DATE:
March 29, 2021

PROJECT:
Route 66 Veterinary Emergency
and Critical Care Center
3601 Central Ave N.E.
Albuquerque, NM 87108

RE:
TCL Comments, Response Narrative #1

Traffic Circulation Layout

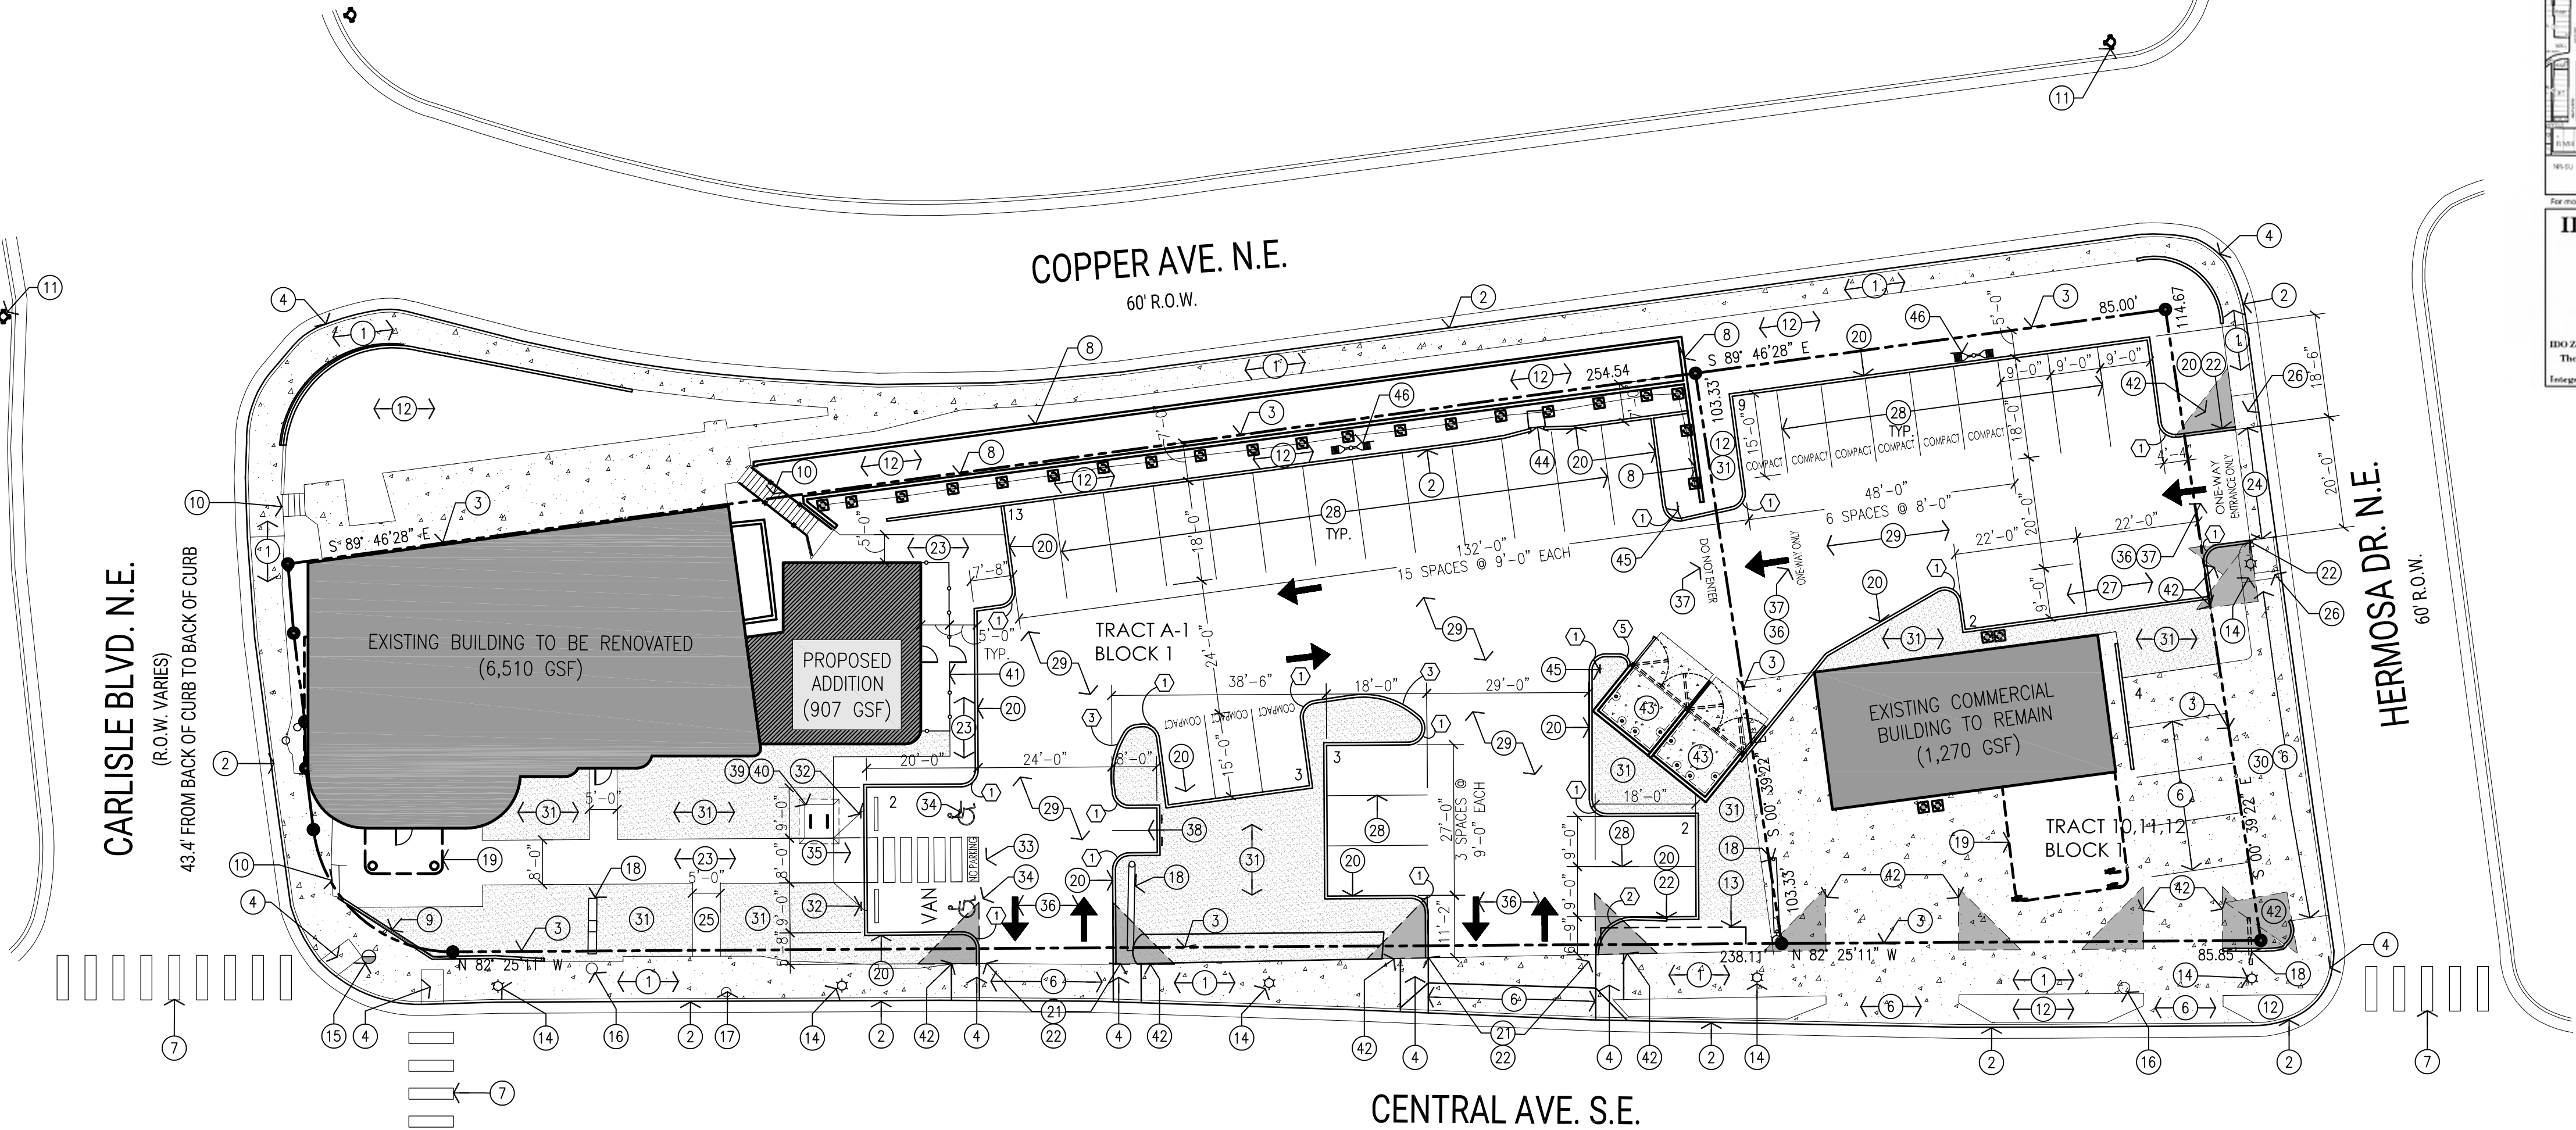
Response: We have received approval from the Fire Marshal for the proposed site plan. See the attached approved Fire 1 Site Plan.
4. Add Do Not Enter signs for the one-way driveway on Hermosa.

Response: "Do Not Enter" pavement signage has been included on the one-way driveway off of Hermosa, and pole-mounted "Do Not Enter" signs added to one-way driveway. Refer to updated TCL, and see keyed notes 36, 37, and 45.

5 Bicycle Rack Partial Plan Detail  
Scale: 3/4"=1'-0"

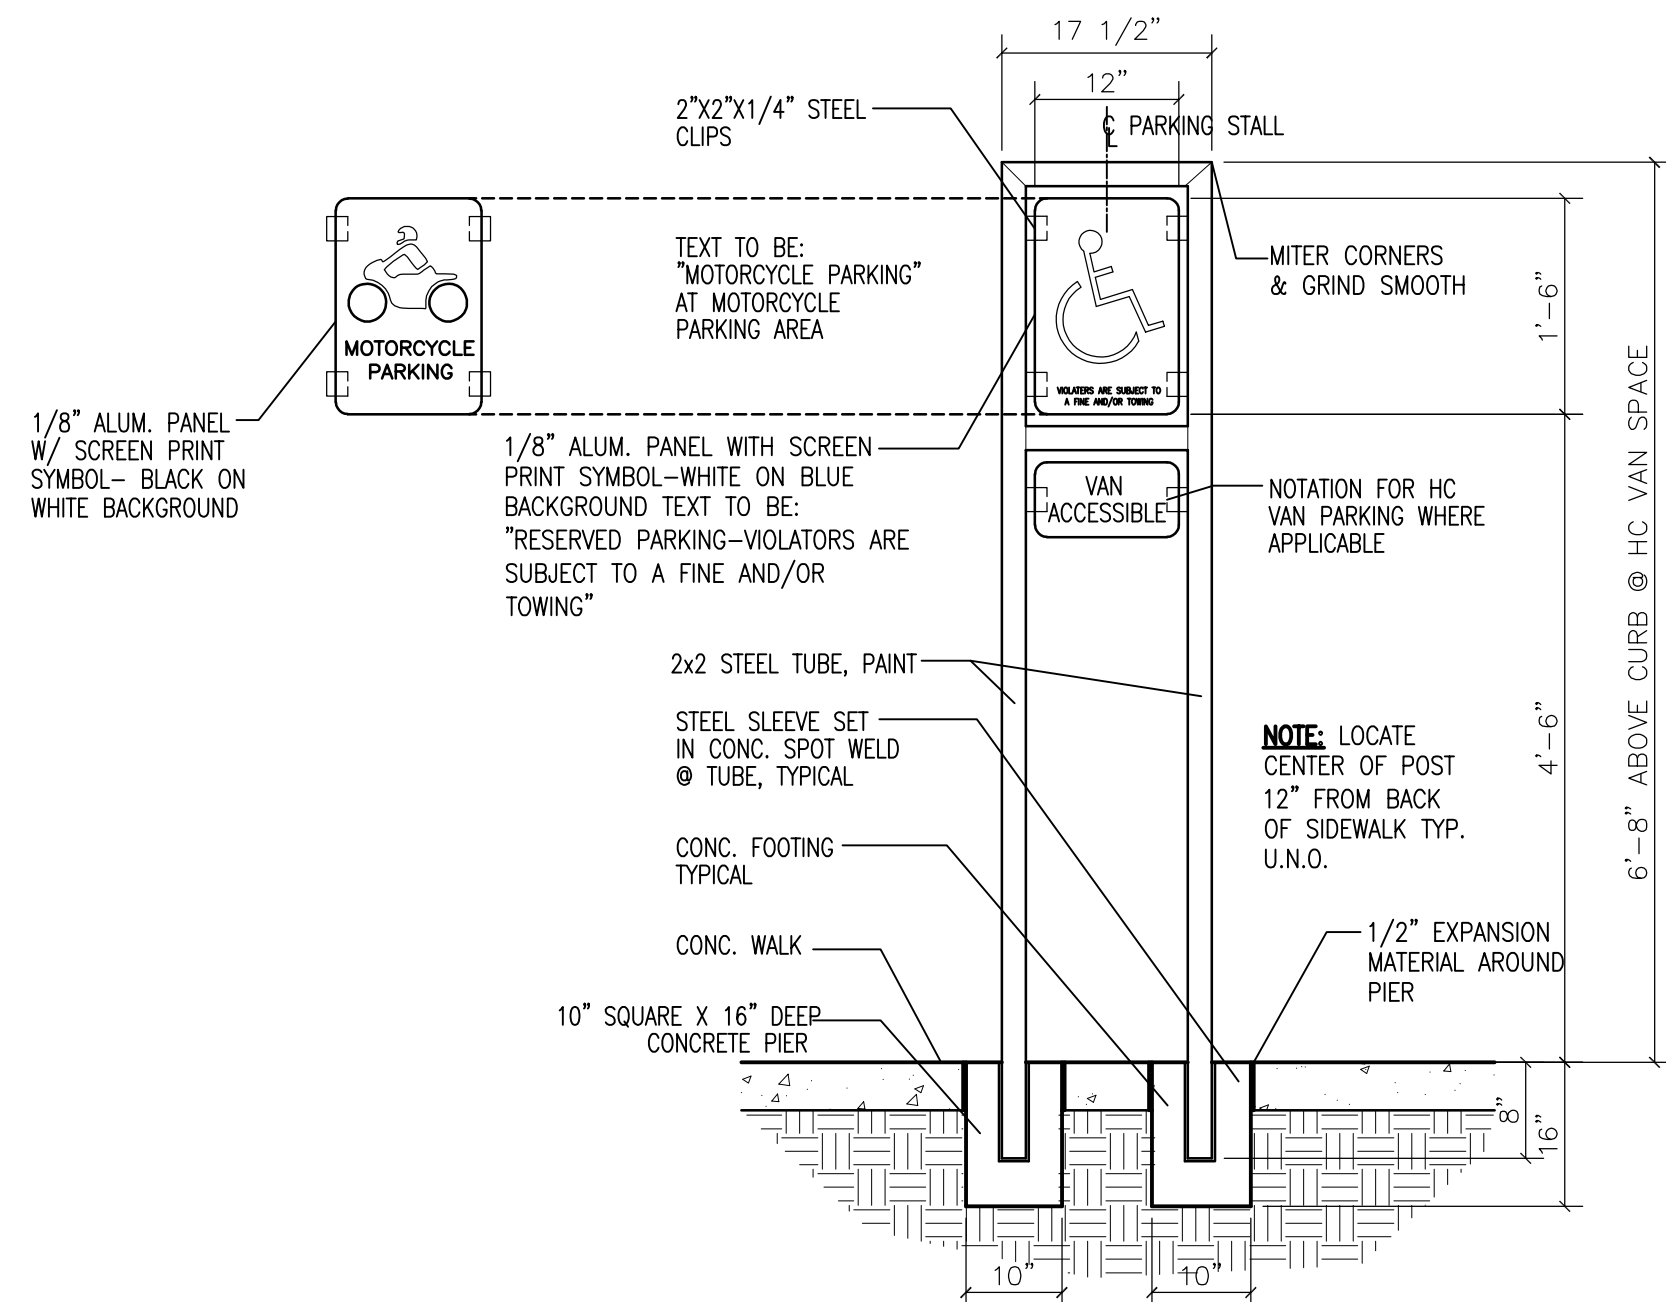
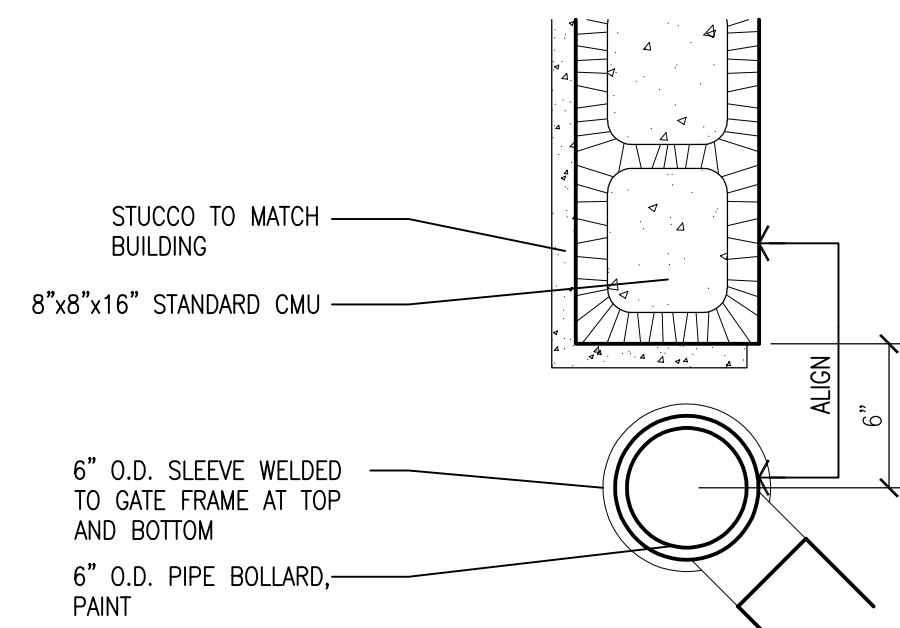
6. Provide bicycle parking rack details.
Response: Refer to details 5, 9 and 12 on updated Site Details, sheet A002 for bicycle rack details.
7. Show motorcycle parking sign location.
Response: Refer to keyed note 38 on the TCL which references the sign detail 6/A002.
8. Plans must be sealed and signed by a licensed NM RA or PE.
Response: Updated TLC and Site Details, Sheets A002 and A003 have Updated architect's stamp has been added to drawings.

6 HC / Motorcycle Parking Sign Detail  
Scale: 3/4"=1'-0"

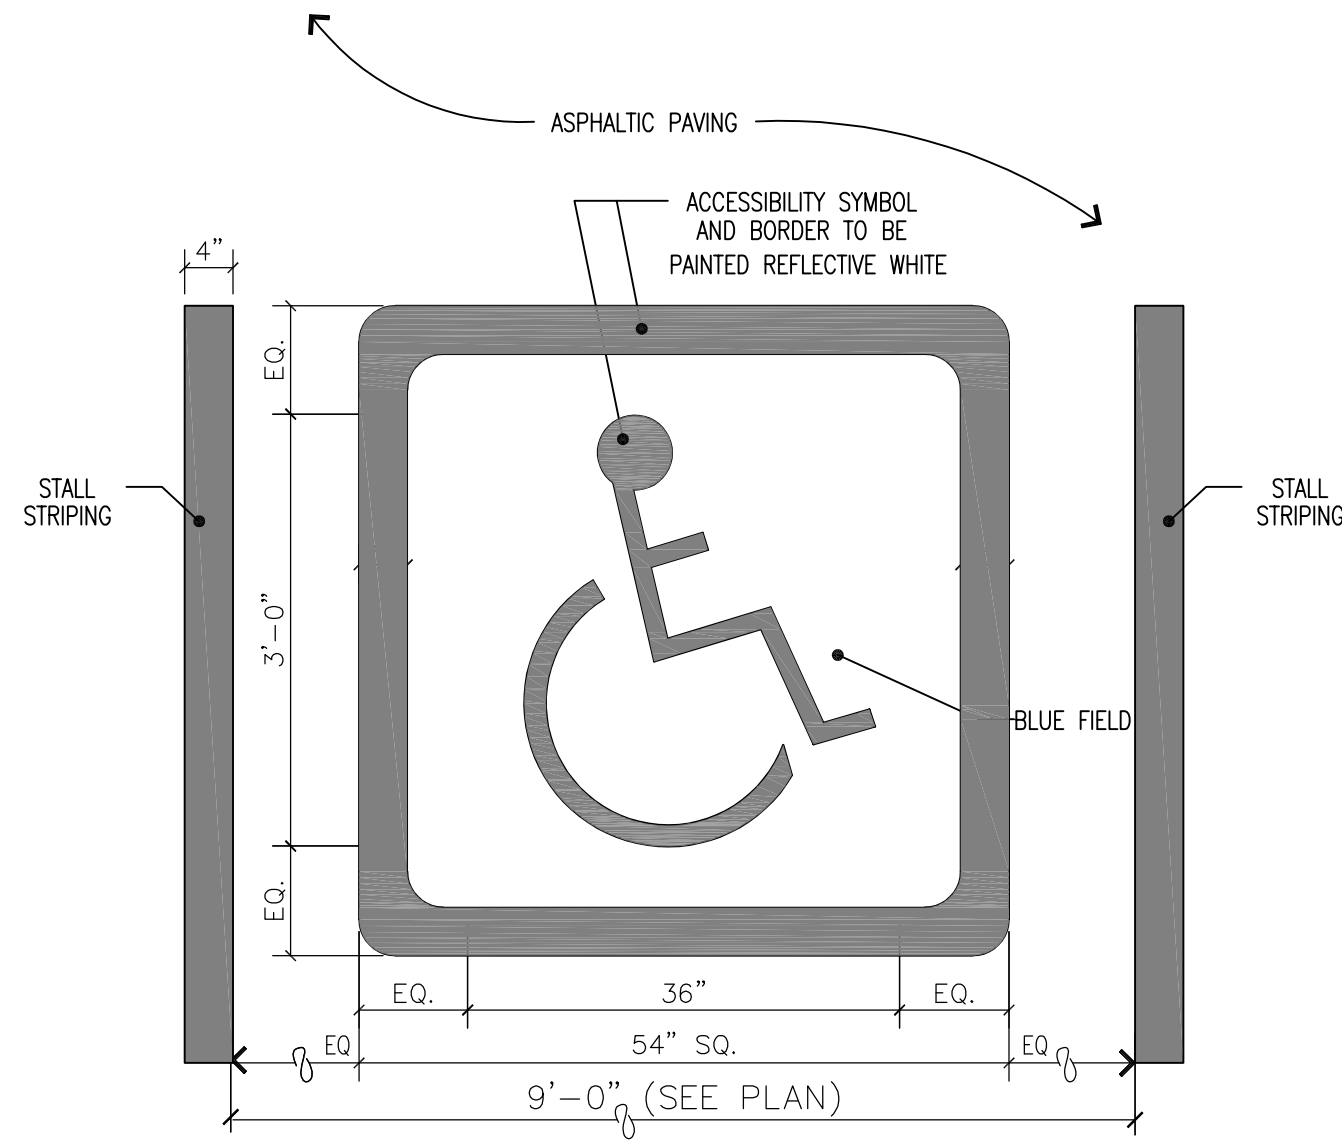
5. Provide sign face details drawings for ADA parking, Motorcycle parking and Do No Enter Signs.
Response: Refer to detail 6/A002 for sign detail for these conditions on the updated Site Details, sheet A002.
